**WELWYN HATFIELD BOROUGH COUNCIL
EXECUTIVE DIRECTOR - PLANNING, PUBLIC PROTECTION AND GOVERNANCE**

Application No: 6/2018/0297/LAWP
Location: Manor Cottage Vineyards Road Northaw Potters Bar EN6 4PQ
Proposal: Certificate of lawfulness for the erection of two single storey side extensions and an outbuilding
Officer: Mr David Elmore

Recommendation: Refused

SCALE @ A2: 1_200 **DRAWING No:** MC-R00-PR-105

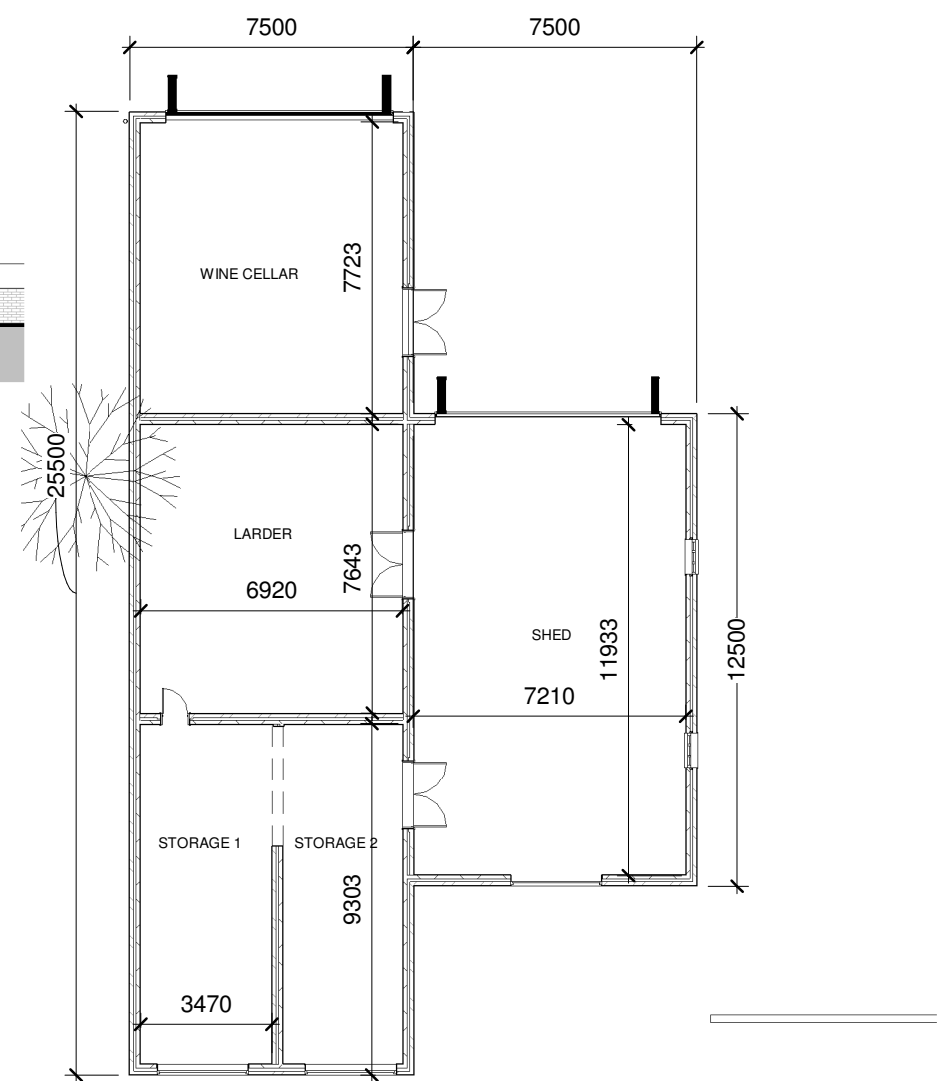
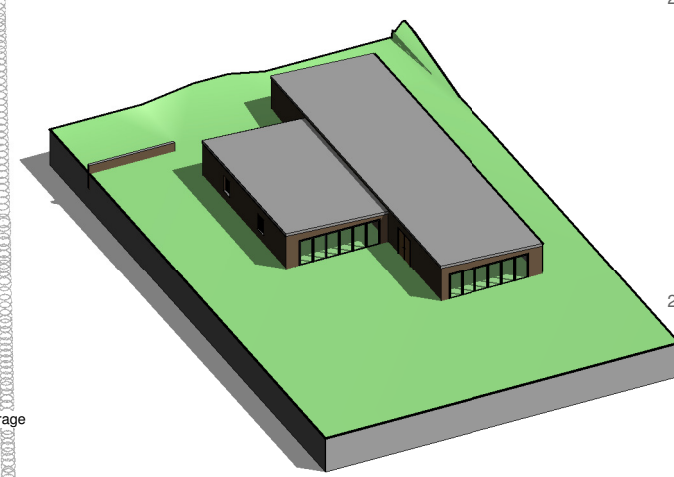
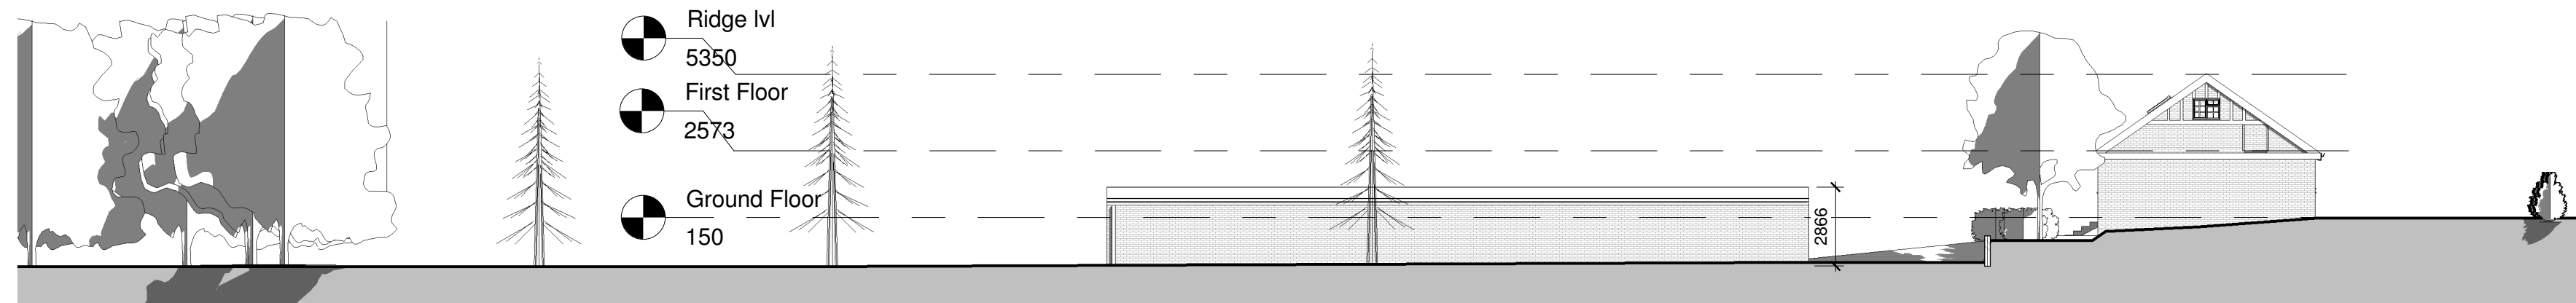
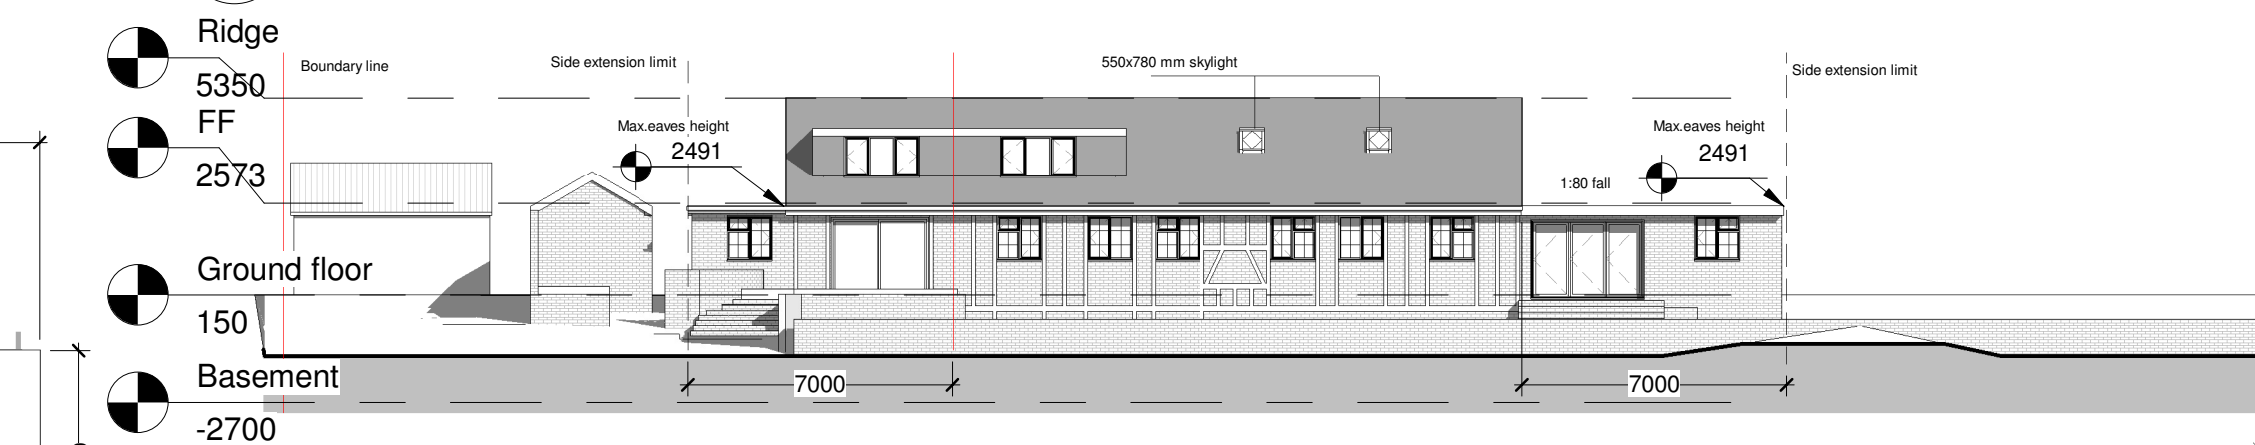
The proposed outbuilding would be situated within the rear garden of the application site and measure 285sqm. It would accommodate a wine cellar, larder, shed and two storage areas. The existing dwelling has a footprint of 169sqm. This proposed outbuilding would therefore have a footprint over one and a half times the footprint (68% to be precise) of what is a large chalet-style bungalow which is substantial. Size alone is not necessarily a determining factor and a wide range of outbuildings, for different purposes may be permitted under Class E, depending on the specific circumstances. Those principles have been established through the Courts, including the cases of Emin and Wallington. The Courts have also established that the term ‘required’ should be interpreted as meaning ‘reasonably required’.

The shed and storage areas of this outbuilding are of an acceptable size to meet the reasonably required test. However, the sheer size of the proposed wine cellar and larder, at 52sqm and 53sqm respectively (measured as gross internal floor area), would be way in excess of what could be considered reasonably required as an incidental use for what is a 4-bedroom family house. Consequently, the proposed outbuilding would fail to accord with Schedule 2, Part 1, Class E of the 2015 GPDO.

The proposed outbuilding, by virtue of the size of its wine cellar and larder, would not be reasonably required for a purpose incidental to the enjoyment of the dwellinghouse. Also, the height of the eaves of the proposed outbuilding exceeds 2.5 metres. This building would fail to accord with Schedule 2, Part 1, Class E of the Town and Country Planning (General Permitted Development)(England) Order 2015 as amended.

2. The proposed outbuilding, by virtue of the size of its wine cellar and larder, would not be reasonably required for a purpose incidental to the enjoyment of the dwellinghouse. Also, the height of the eaves of the proposed outbuilding exceeds 2.5 metres. This building would fail to accord with Schedule 2, Part 1, Class E of the Town and Country Planning (General Permitted Development)(England) Order 2015 as amended.
